From: Dominic Morris <Dominic@wlma.org.uk>
Sent: 12 April 2017 12:21
To: Jon Sharpe
Cc: HighwaysSUDsSupport; _planningadvice; a.wright369@btinternet.com; Des Ford
Subject: H09-0326-17 Wignals Gate Holbeach
Attachments: DM-2017PAF0326-01-DM- D Brown Building Contractors Ltd.pdf; Application for Direct Discharge of Surface Water - SHIDB _May 2014.pdf; Application for a relaxation of Byelaw 10 _May 2014.pdf; Application for a relaxation of Byelaw 10 Guidance Notes _March 2013.pdf

OUTLINE PLANNING APPLICATION – H09-0326-17

PROPOSED RESIDENTIAL DEVELOPMENT

APPLICANT: D BROWN BUILDING CONTRACTORS LTD

Proposed Enlarged
Drainage Layout

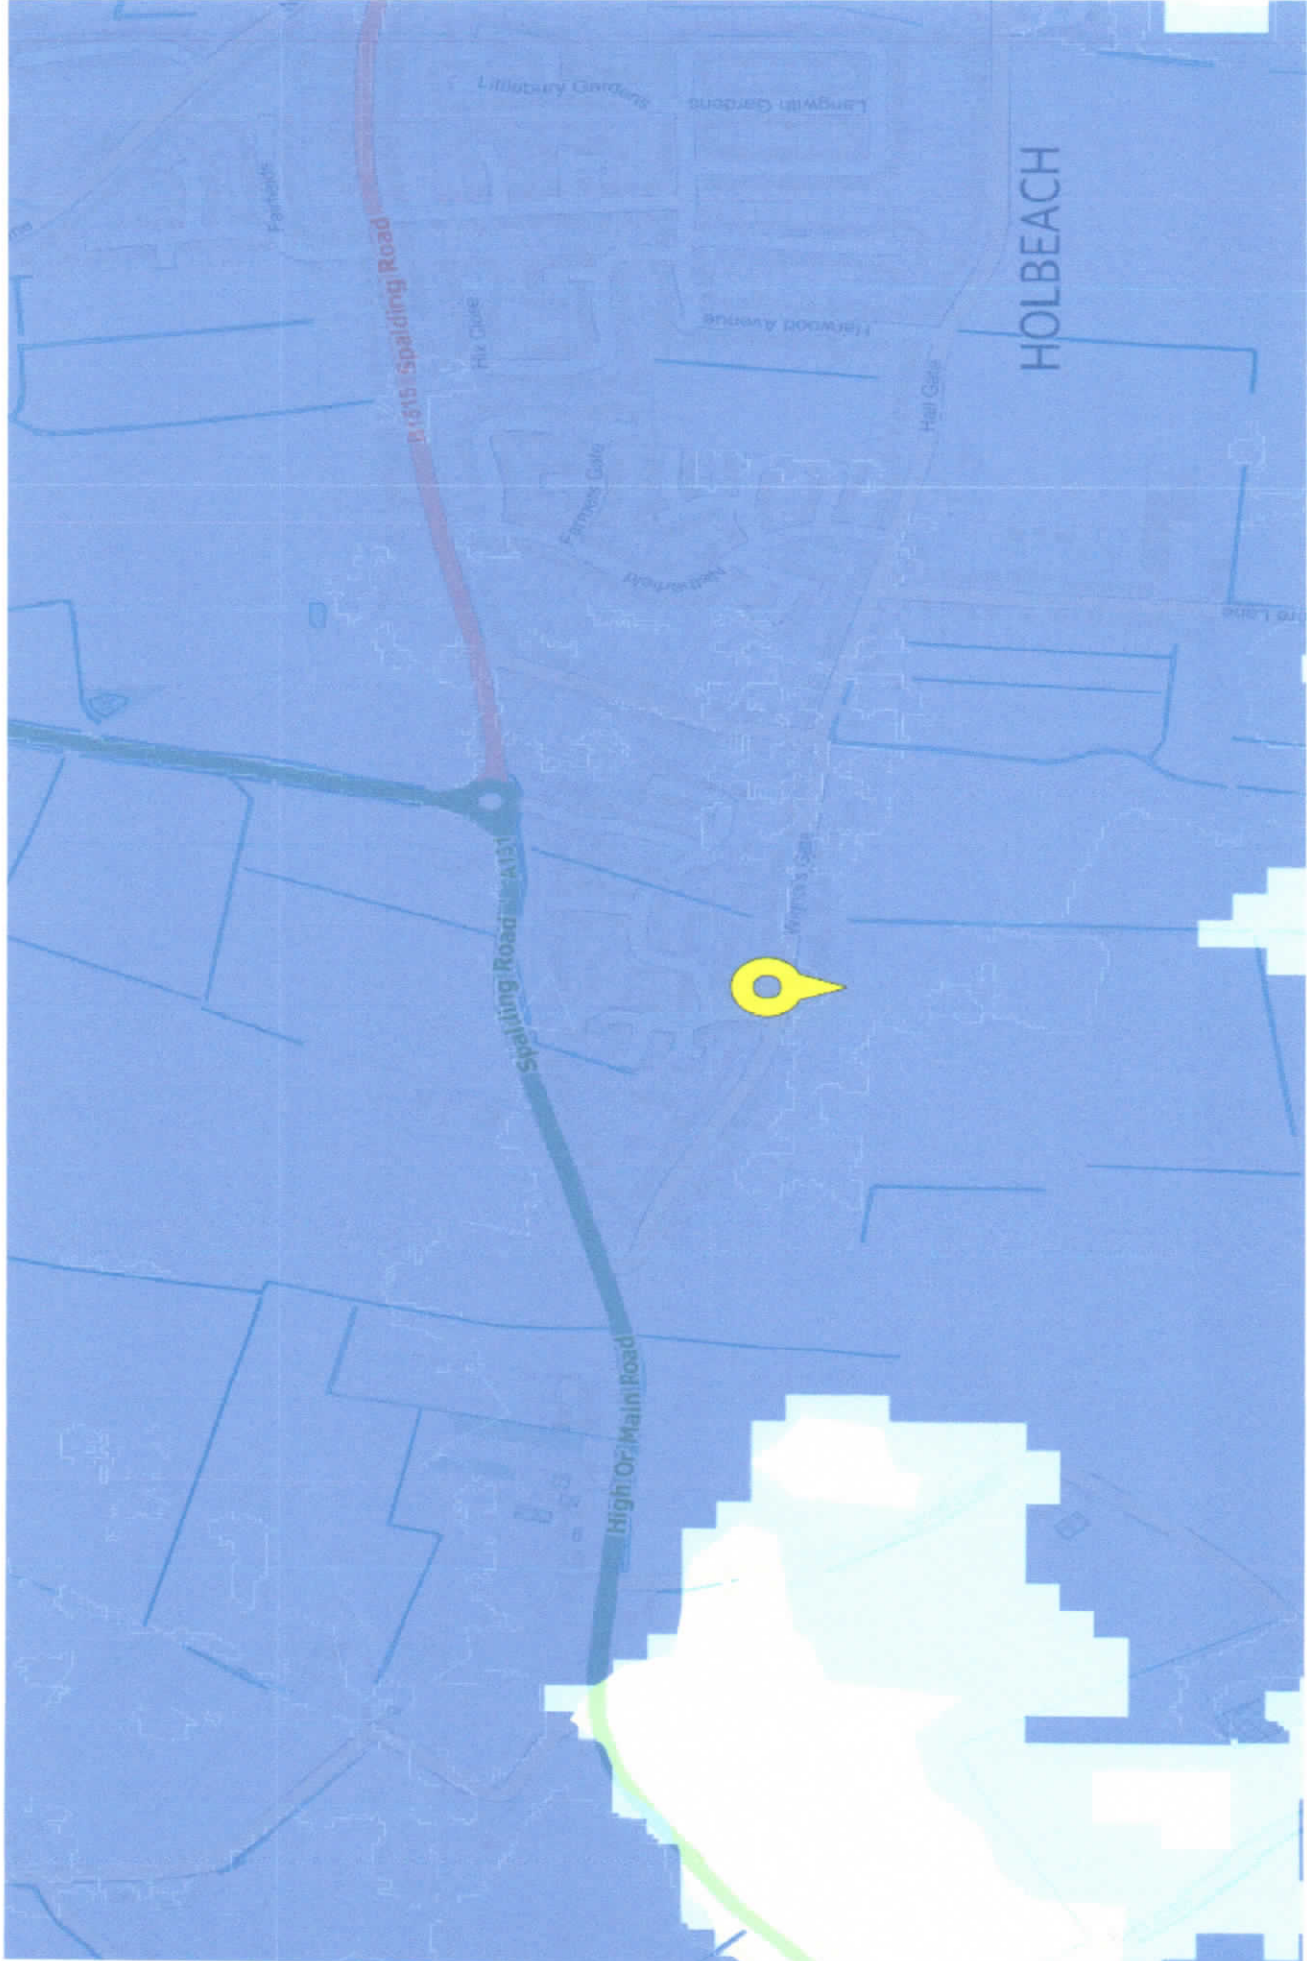
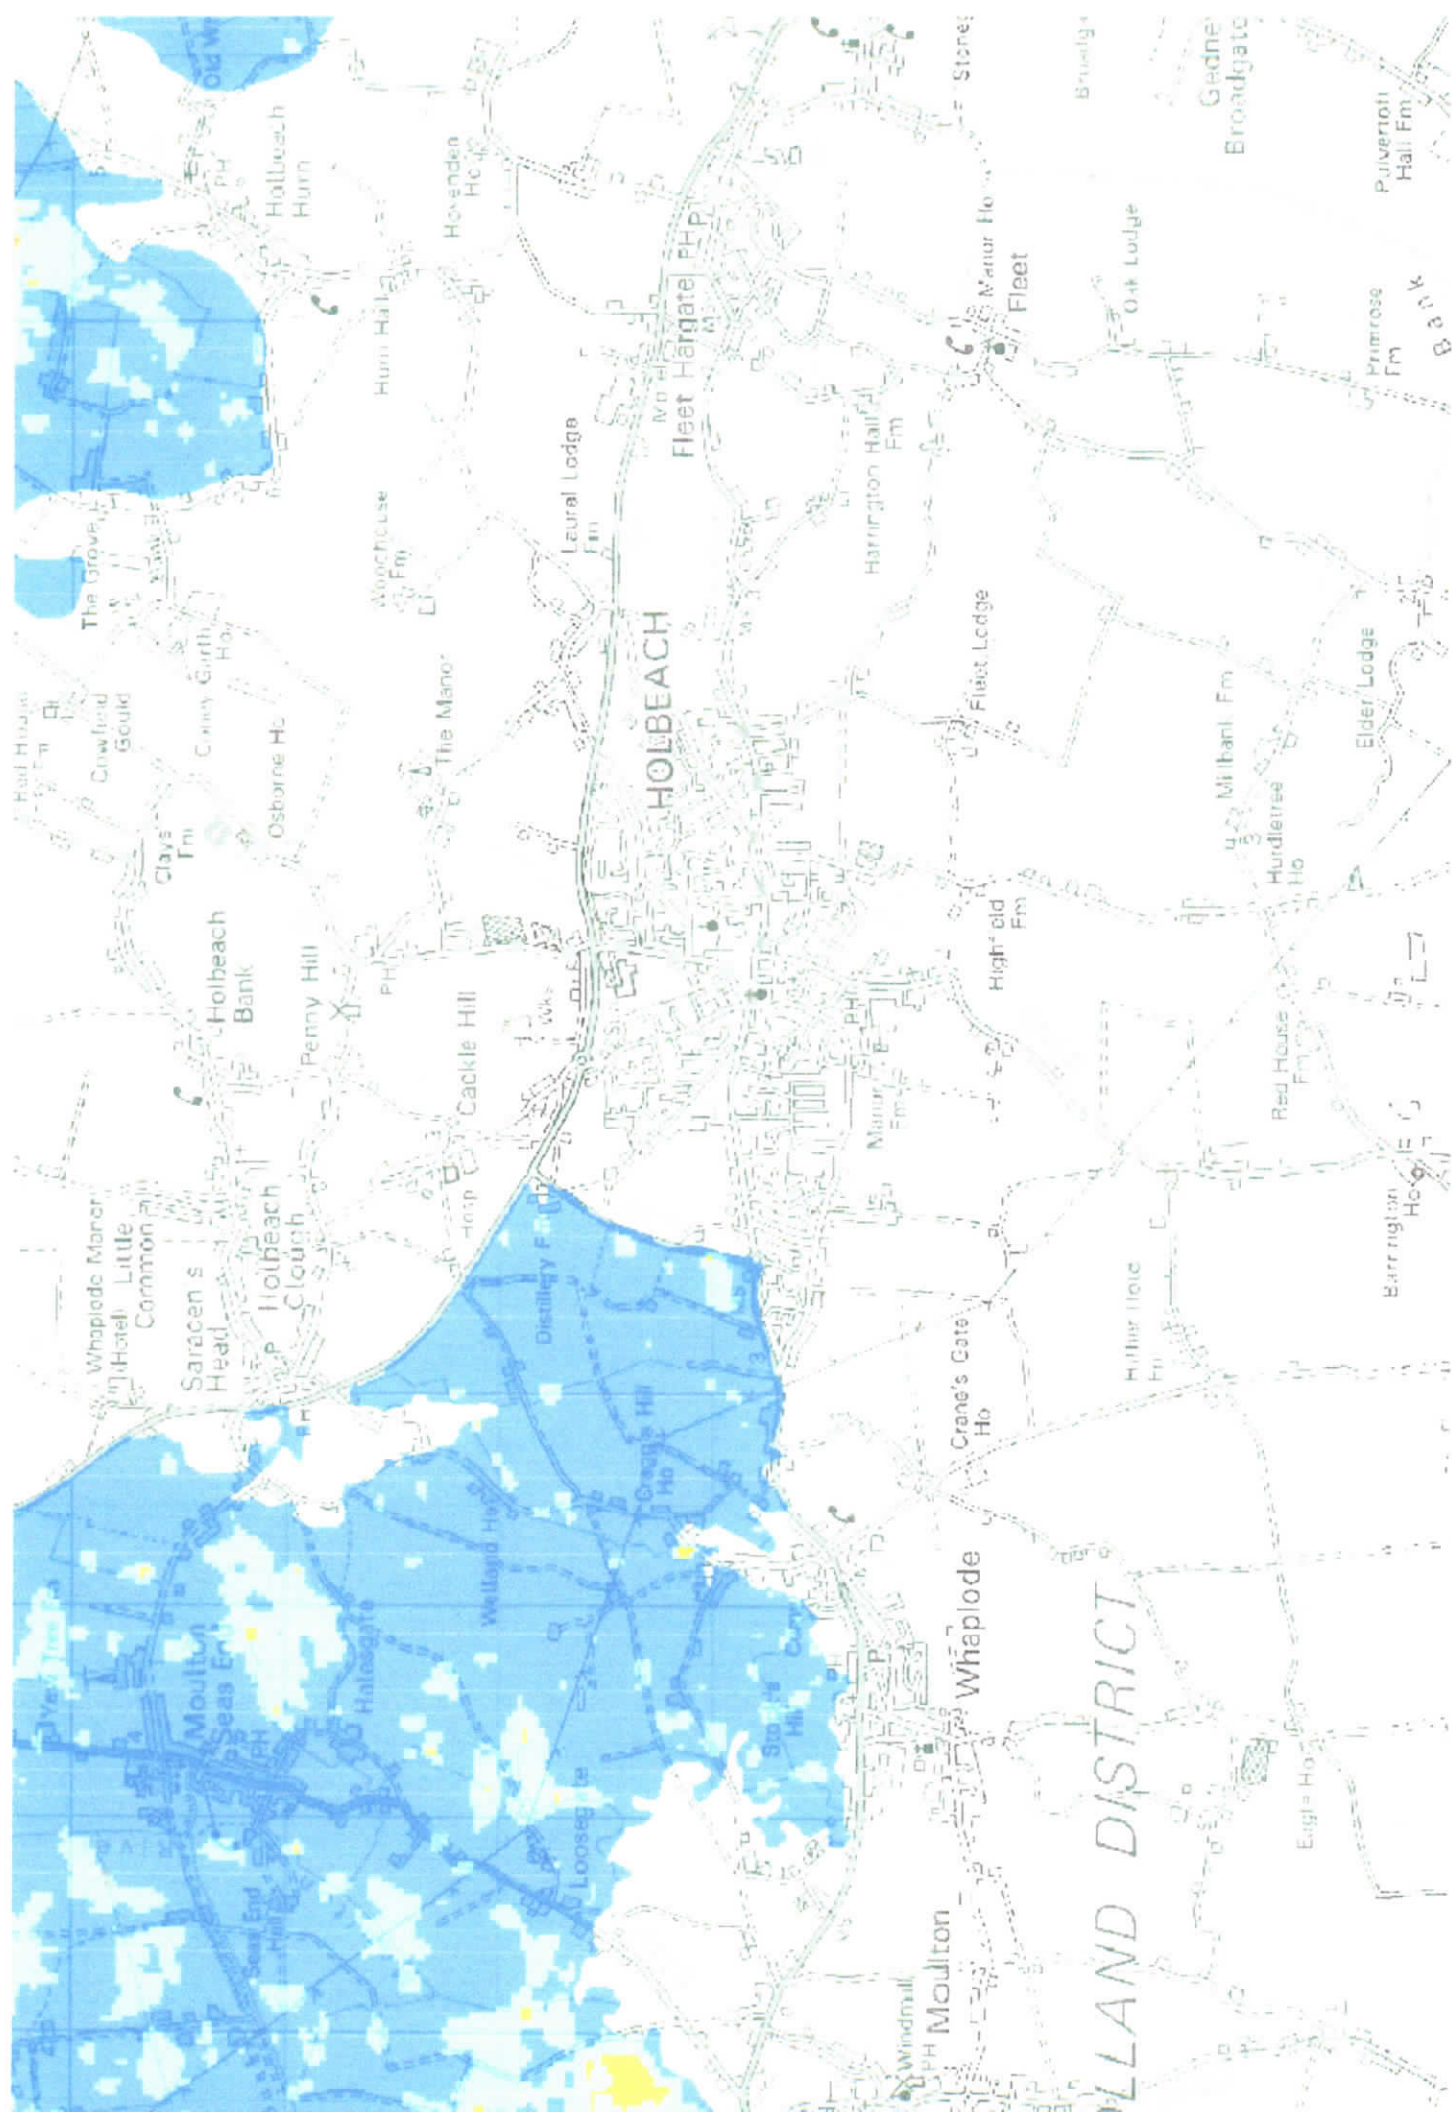
- With regards to surface water disposal for the proposed development, the Board would accept a discharge rate of 1.4litres a second per hectare entering their watercourse. A flow control unit/structure would be required to restrict the flow rate down to 1.4litres a second per hectare entering the Board's system. An application form is attached for the applicant's attention, there is a £100 application fee payable on return of the application form. If the Board consent to the additional volume/flows, the applicant will have to pay a Surface Water Development Contribution which is £7.55 a square metre for the impermeable surface created by the proposed development. The overall payment will be reduced to 20% of the total fee providing the discharge rate is kept to 1.4litres a second per hectare. However, if there is an overflow fitted, this would be classed as an unrestricted discharge and the full amount will be payable.

- There is no proposed source control to be installed for the proposed development to help reduce the flow and quality of the surface water entering the drainage system. The Board would like the drainage layout showing how the flow rate is going to be controlled/reduced to 1.4litres a second per hectare.
